Our Reference: SYD18/01322/23

Departments Reference: SSD 9522

RESPONSE TO SUBMISSIONS ADDENDUM - KEMPS CREEK WAREHOUSE, LOGISTICS AND INDUSTRIAL FACILITIES HUB (SSD 9522)

Strategic Plan – Prepared by MU Group

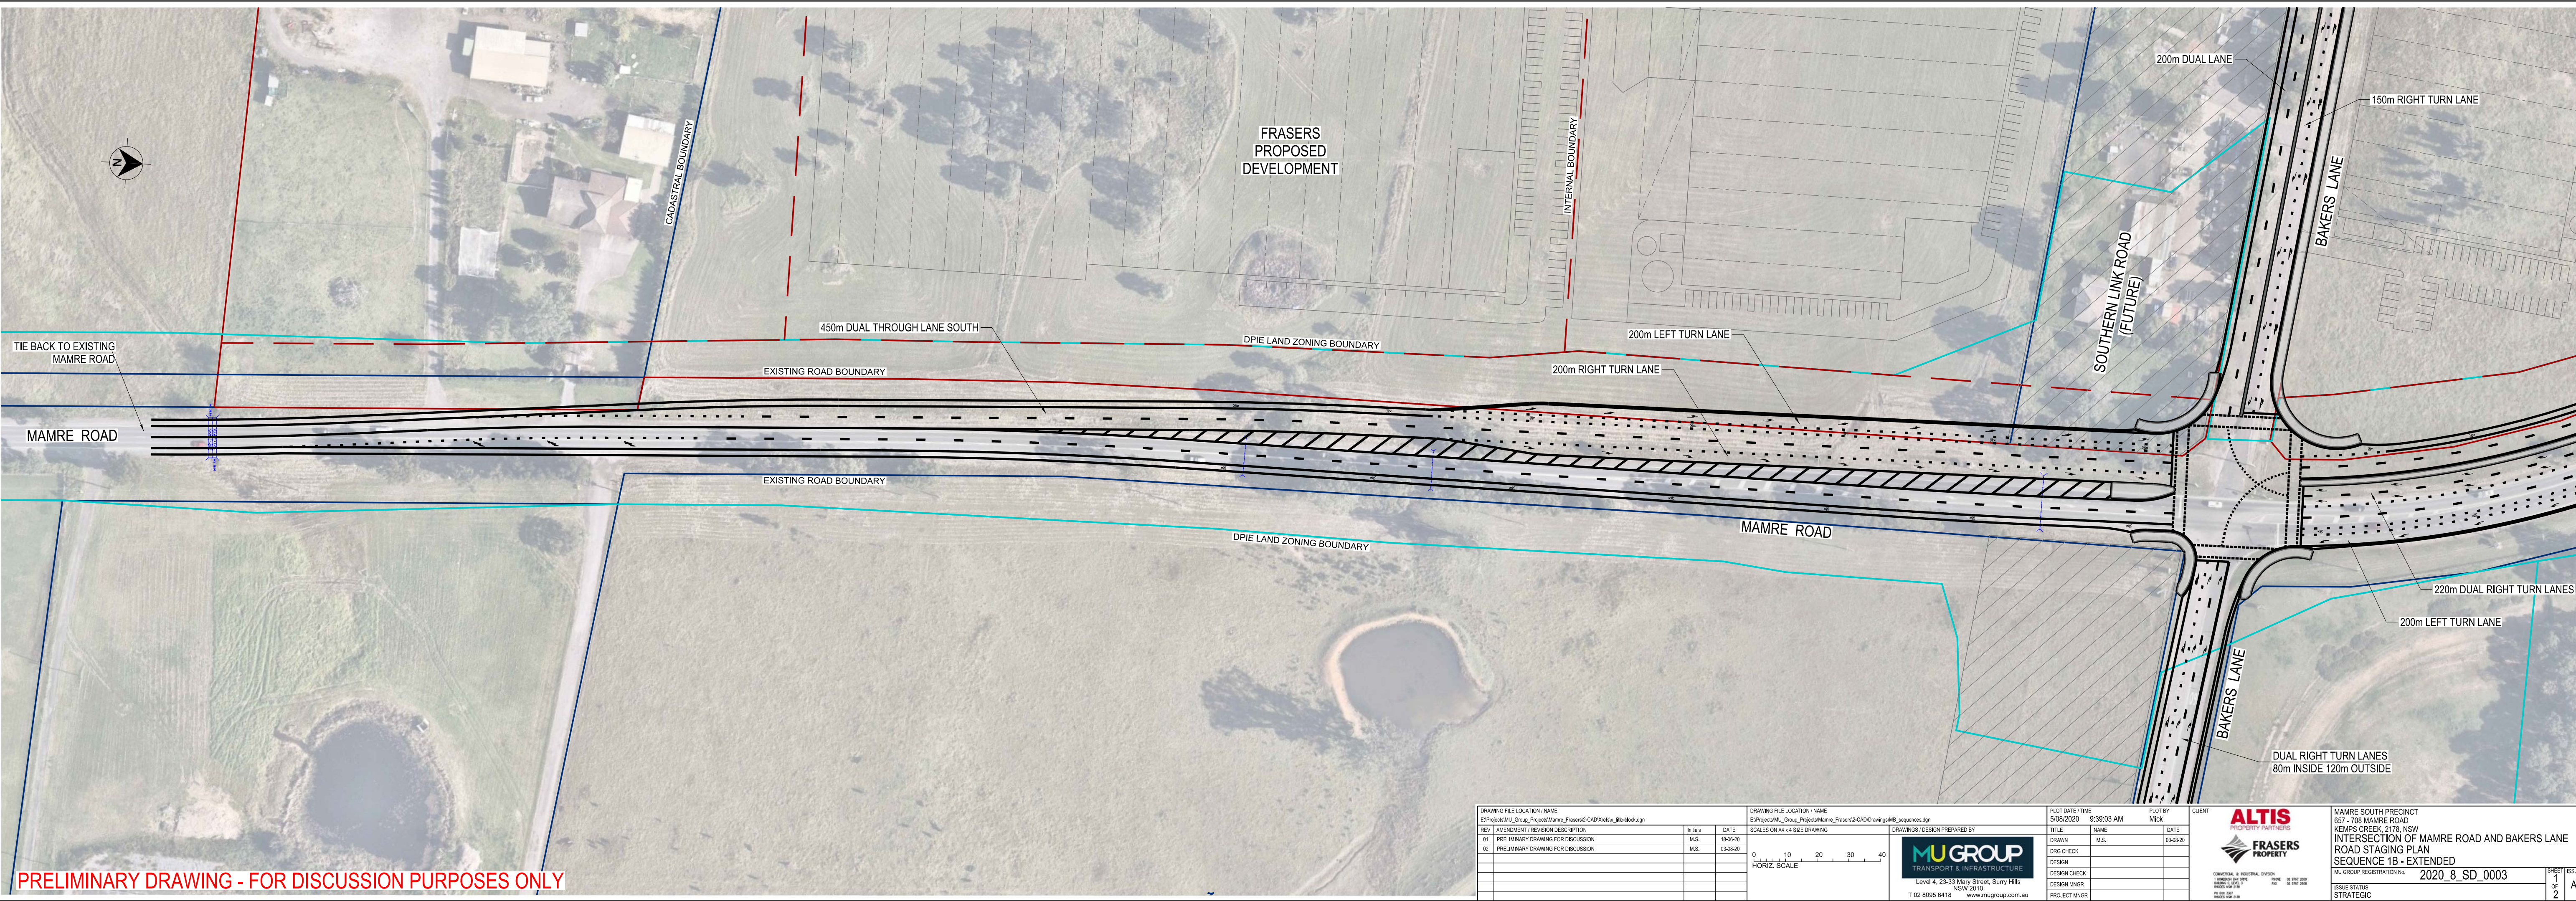
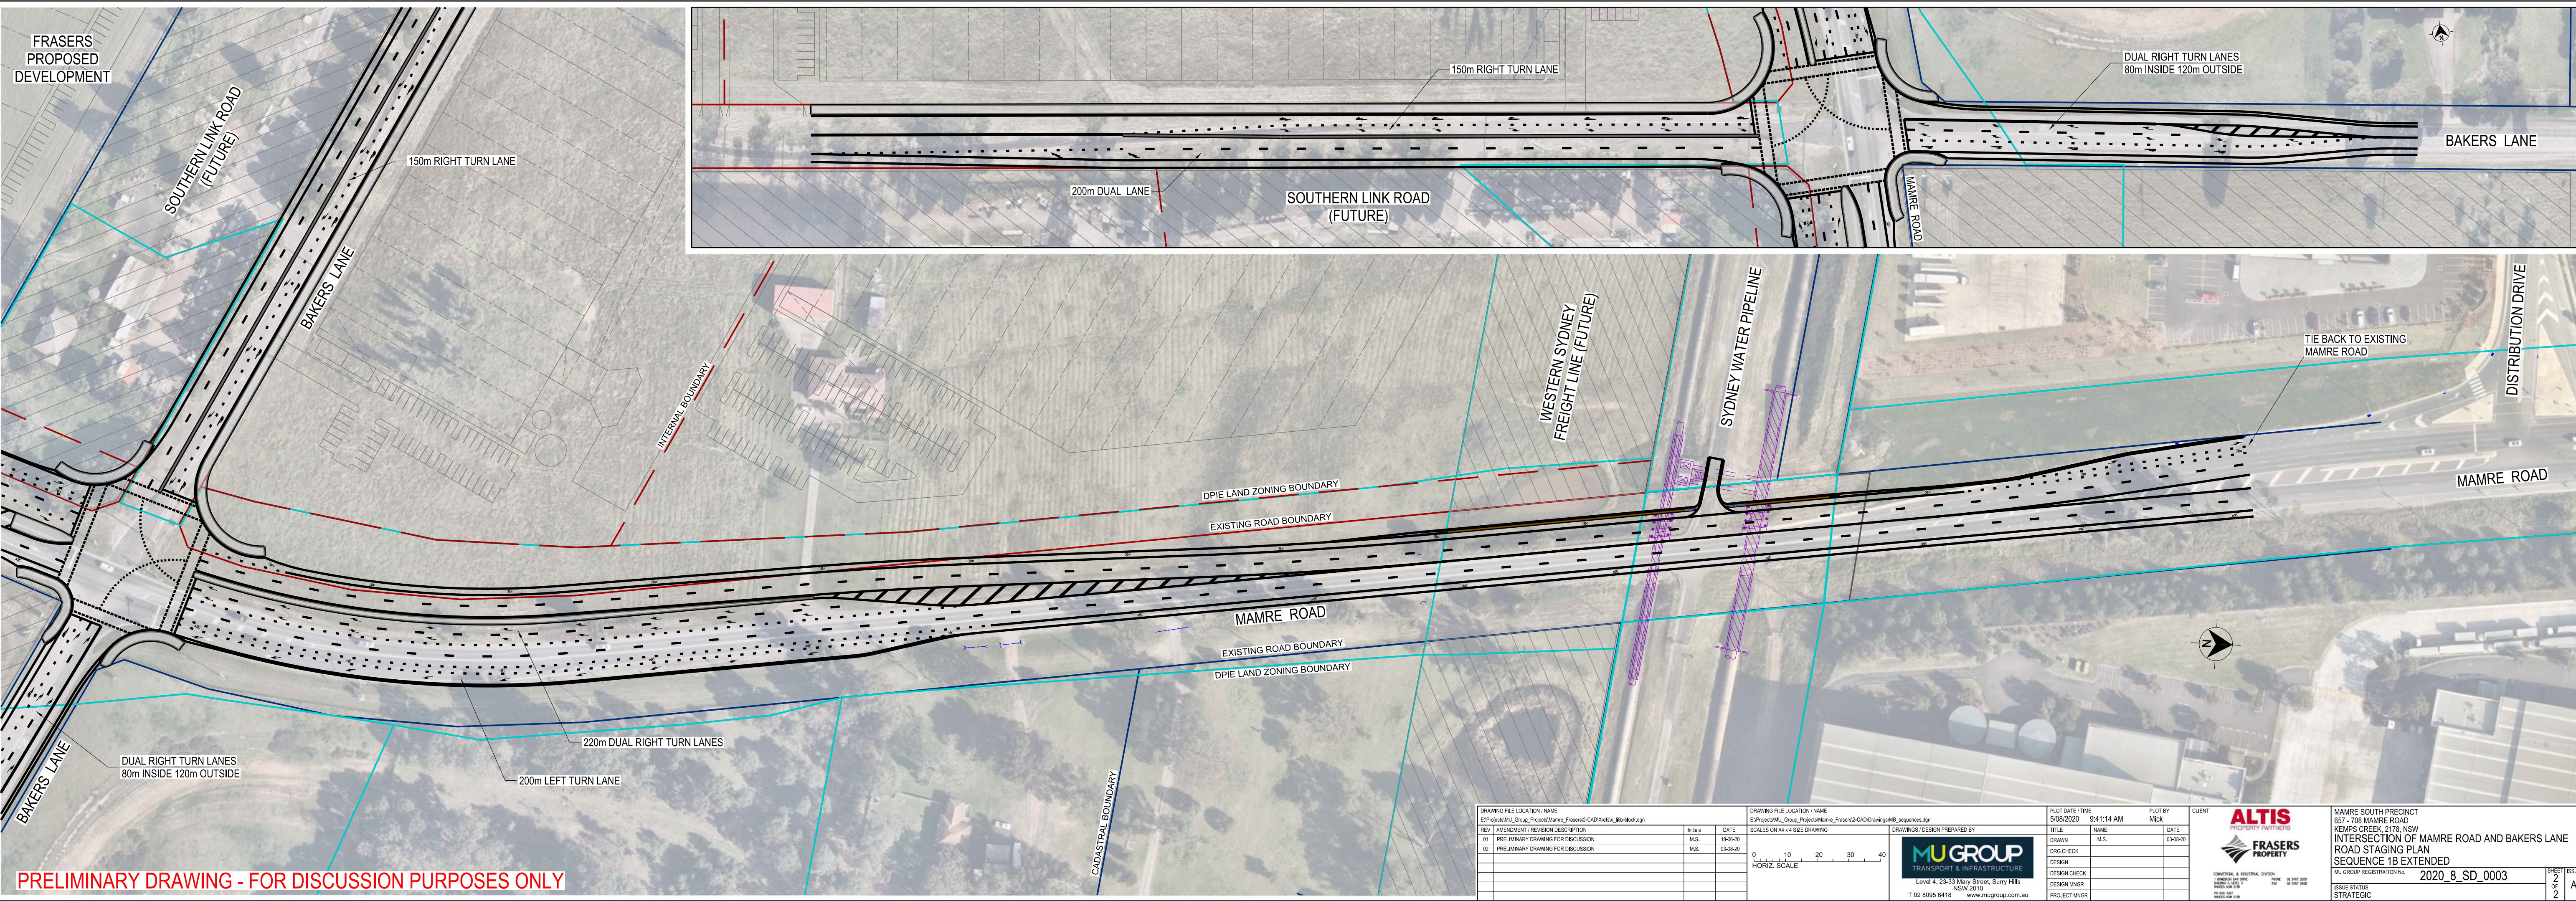
1. TfNSW previously noted the documentation provided is not consistent. The response to submissions addendum, states that the design provided in this SSDA cannot be achieved within the existing SP2 corridor for Mamre Road. Any changes to the design may alter the LoS to the intersection and therefore the modelling and traffic report provided will not be accurate. This could lead to unknown delays to the network and adverse safety outcomes. Therefore noting the above, TfNSW cannot provide support under Section 87 of the *Roads Act, 1993*.

- i. Concept (or Strategic) Civil plans
 - ii. Draft Traffic Control Signal (TCS) plans
 - iii. Swept Path Plans
 - iv. Traffic Report – information is to be consistent with the actual proposed design
 - v. Warrant Assessment
 - vi. Land Owners Consent (If required)
2. In addition to the above point TfNSW provides the following high level design comment which is required to be incorporated into the design prior to further review of the intersection of Mamre Road/Bakers Lane. The swept path diagram provided indicates that the left turn into the Bakers Lane (east) is restricted to a 19 metre semi-trailer. As this is a new signalised intersection within an industrial land development TfNSW requires the whole intersection to be designed for a 26 metre B-double vehicle. Consideration should also be made in the design to accommodate for a PBS 3 Access Class A (36.5 metre) heavy vehicle.
